Report following a request for further information, negotiations or consultation

REF NO: P/155/21/RES

LOCATION: Land West of Pagham Road
Pagham

PROPOSAL: Approval of reserved matters (layout, scale, appearance and landscaping) following outline consent P/140/16/OUT for the 'local centre' parcel which comprises of retail, community and commercial uses, 20 No residential apartments and a 70 bed care home.

PROPOSED DRAINAGE STRATEGY

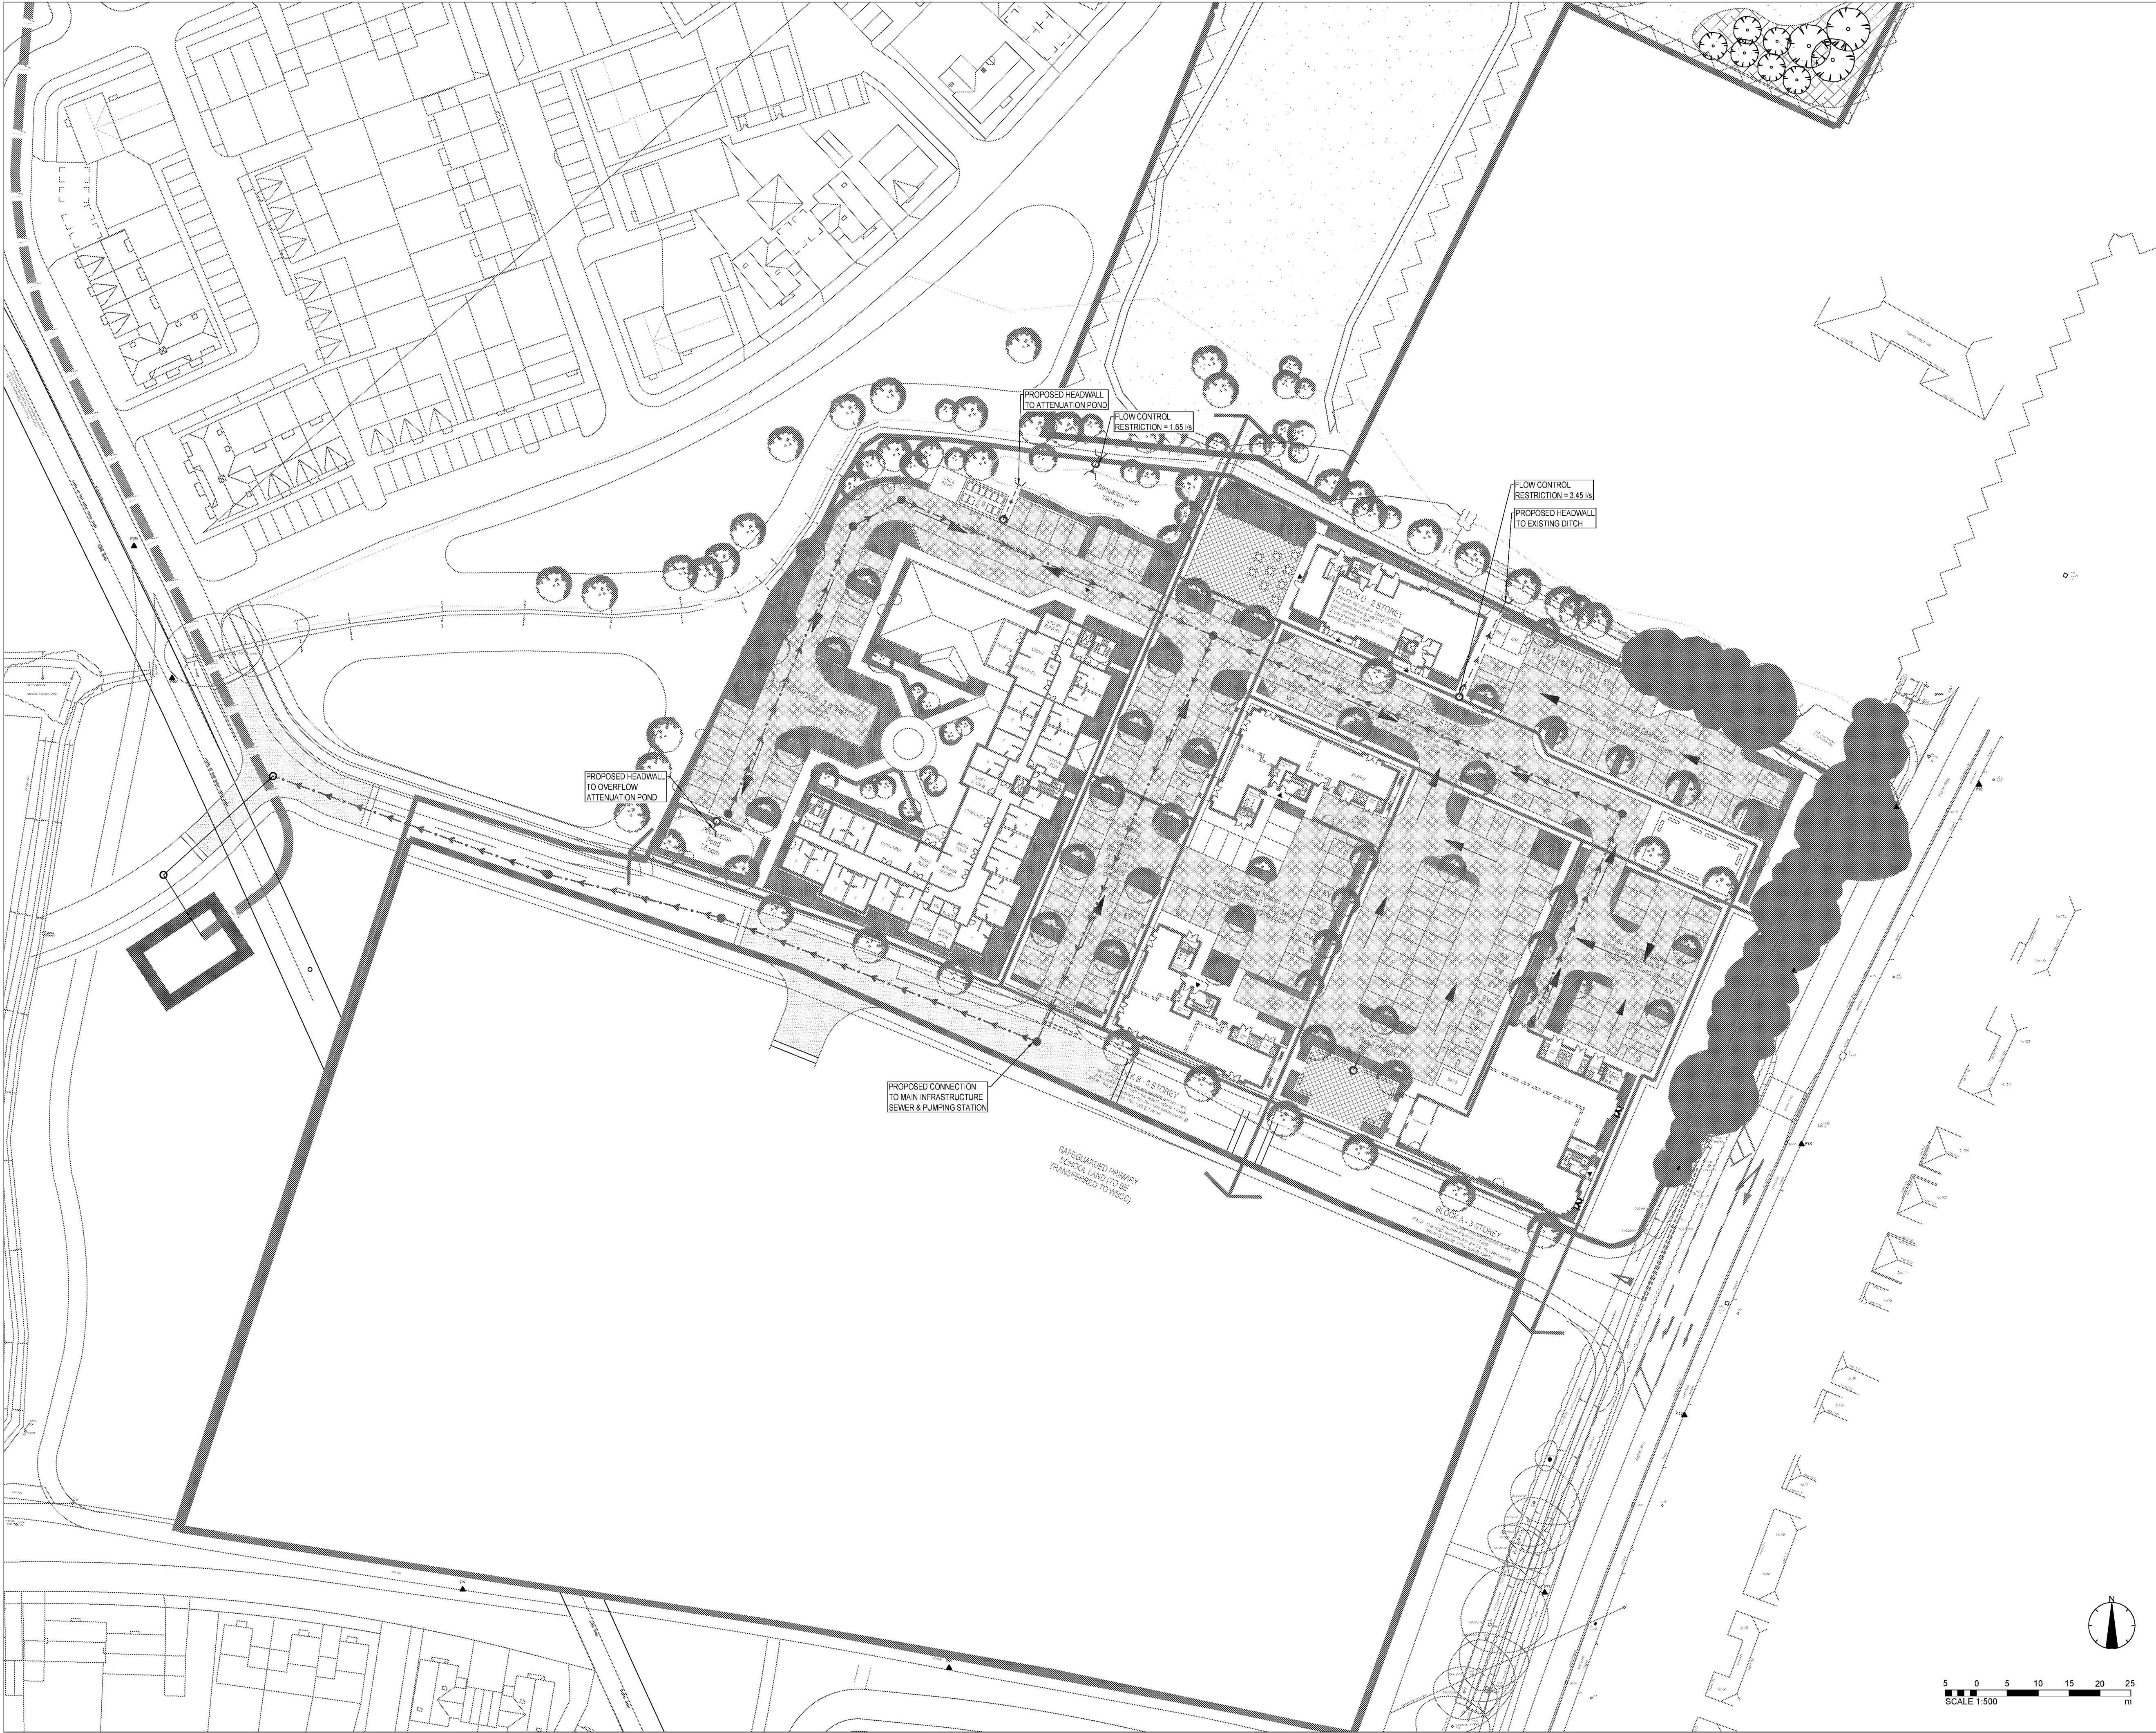
- The technical note responding to our comments does not address our comments.
- Please respond fully to our comments from the 14th December with calculations and high level drainage layouts.

- The proposed discharge rate is too high. The calculation of discharge rates should be based upon the positively drained area. Revised greenfield runoff rate calculations should be supplied.

- Ordinary watercourse land drainage consent is required for all new outfalls and for proposed culverts.
- FEH2013 rainfall data must be applied to calculations.

- Surcharged outfalls should be applied to calculations. The surcharged outfall levels should be set to adjacent top of bank level.
- A minimum of two perpendicular cross sections per basin must be supplied.

- We note that a number of trees are proposed in close proximity to drainage features. Root potential areas must not conflict with surface water drainage features.

- We would also like to highlight that a full winters groundwater monitoring will be required, even for an attenuation scheme. Peak groundwater level at attenuation features should be established and used in design to evidence that flotation is adequately accounted for in design.

1. Comments from the Council's drainage engineer are noted. However, the position remains as identified within the officer's recommendation report. It is considered that detailed drainage design will need to be resolved through the discharge of relevant conditions imposed on the outline approval. Should the layout be unable to facilitate the necessary drainage infrastructure then it would not be possible for the developer to commence development.
